Centennial Coal

Western Coal Services Project Response to EIS Submissions

October 2013

Figure 4 Noise Sensitive Receptors Blackmans Flat Detailed

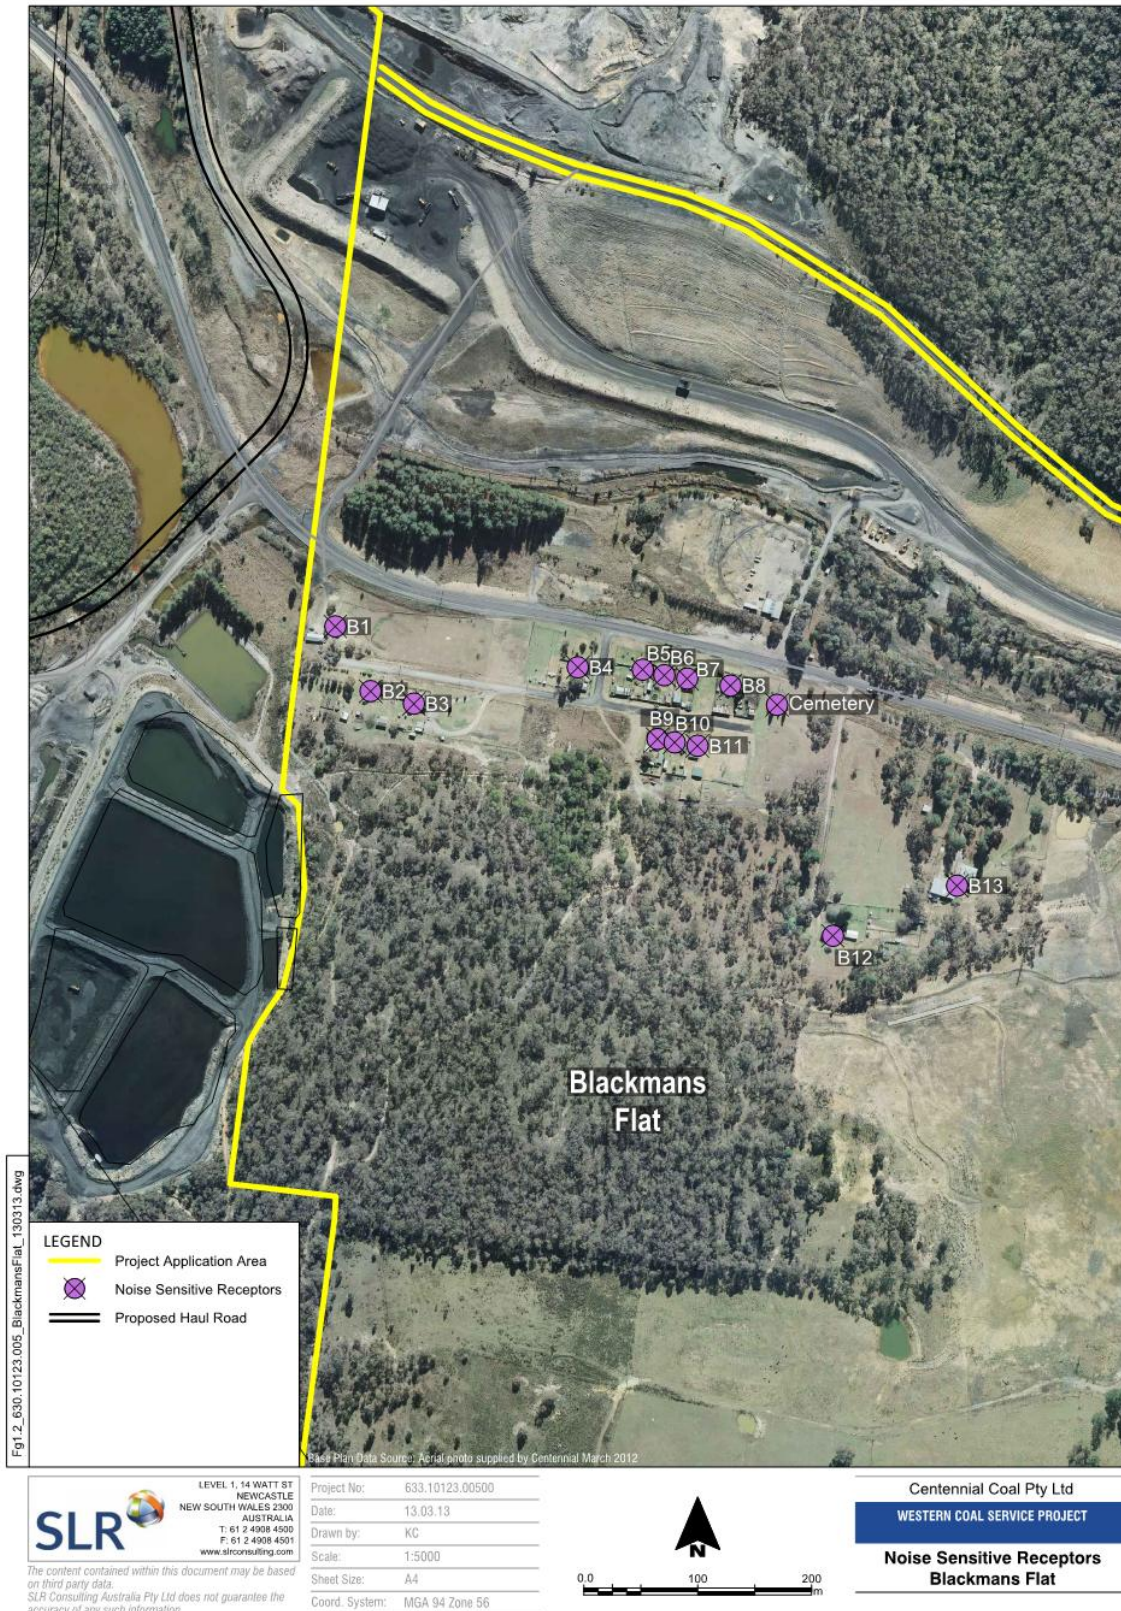
<p>The EPA consider the PSNL to be generally acceptable, however note that the proponent has used quarterly background noise monitoring data obtained over the period December 2010 to September 2012 at locations S1, S2 and S3, which includes noise emissions from the subject site. The</p>	<p>Centennial is investigating, though the Springvale Section 75W Modification dated September 2013, noise mitigation strategies for the Springvale Pit Top. It is anticipated that through this modification PSNLs for these residences will be derived.</p>

Authority	Issue	Response
	<p>proponent has processed this data to determine the lowest 10th percentile values, which it then considers representative of background noise levels at these locations in the absence of Springvale operations. The use of the lowest 10th percentile value is acceptable provided that data shows Springvale ceased operations (and hence its noise emissions did not contribute significantly to the overall RBL) for 100/0 or more of the monitoring period. The EPA considers that such further information on the operating periods for Springvale Coal Mine is required before it can support this approach.</p>	
	<p>The assessment predicts exceedances of the PSNL that must be addressed by the proponent in accordance with Chapters 8 and 9 of the INP. EPA will then be in a position to recommend noise limits for all residences predicted to receive noise levels up to and including the PSNL. For any other receivers predicted to receive noise levels above the PSNL, DPI is best positioned to weigh the social and economic benefits of the proposal against potential adverse noise impacts and to determine if a higher noise limit is justified. If a higher noise limit is accepted by DPI following this assessment and consent is granted EPA will include these limits in a licence, if one is required.</p>	<p>Exceedences of the PSNL are predicted to occur for some residences within the village of Blackmans Flat. Although not stated in the Noise Impact Assessment, the EIS states that Springvale Coal has developed a strategy to manage the impacts on Blackmans Flat.</p> <p>To date, Springvale Coal has purchased five of nine properties and has written agreements with a further three residents within the Blackmans Flat residential area. Springvale Coal is continuing to negotiate with the remaining resident within the Blackmans Flat residential area.</p>

Figure 7 Noise Sensitive Receptors Wolgan Road

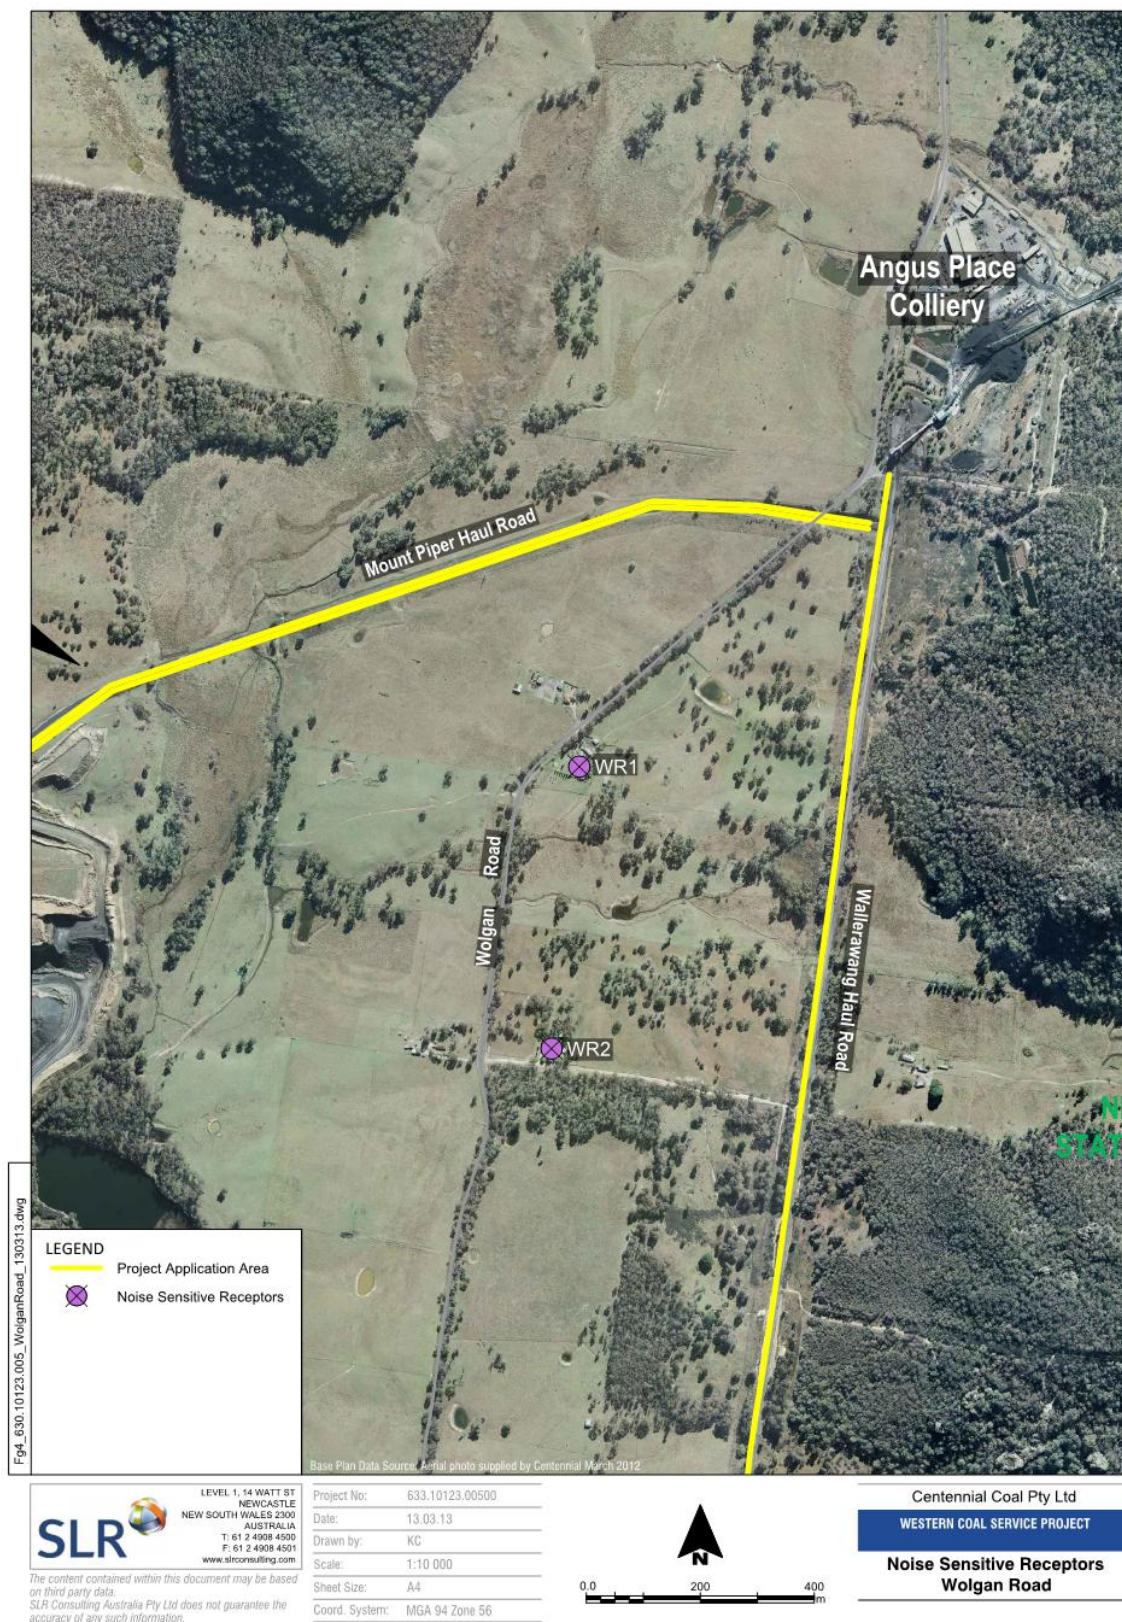
<p>The proponent needs to provide in Tables 45 and 46 the predicted noise levels for inversion scenarios.</p>	<p>Tables 45 and 46 of the NIA show predicted operational noise levels at Wolgan Road Residents which are affected by the operation of the haul roads. Predictions under temperature inversions are not provided as there is a commitment to limit trucking during inversion conditions and therefore not applicable.</p>
	<p>The EPA generally supports the components of the proponent's Statements of Commitments for surface water management, as detailed in Part 5 of Table 67</p>	<p>The Statement of Commitments (commitment 5.8) has been revised to reflect that the application to relocate LDP006 will be made within 3 months of completion of the clean and dirty water</p>
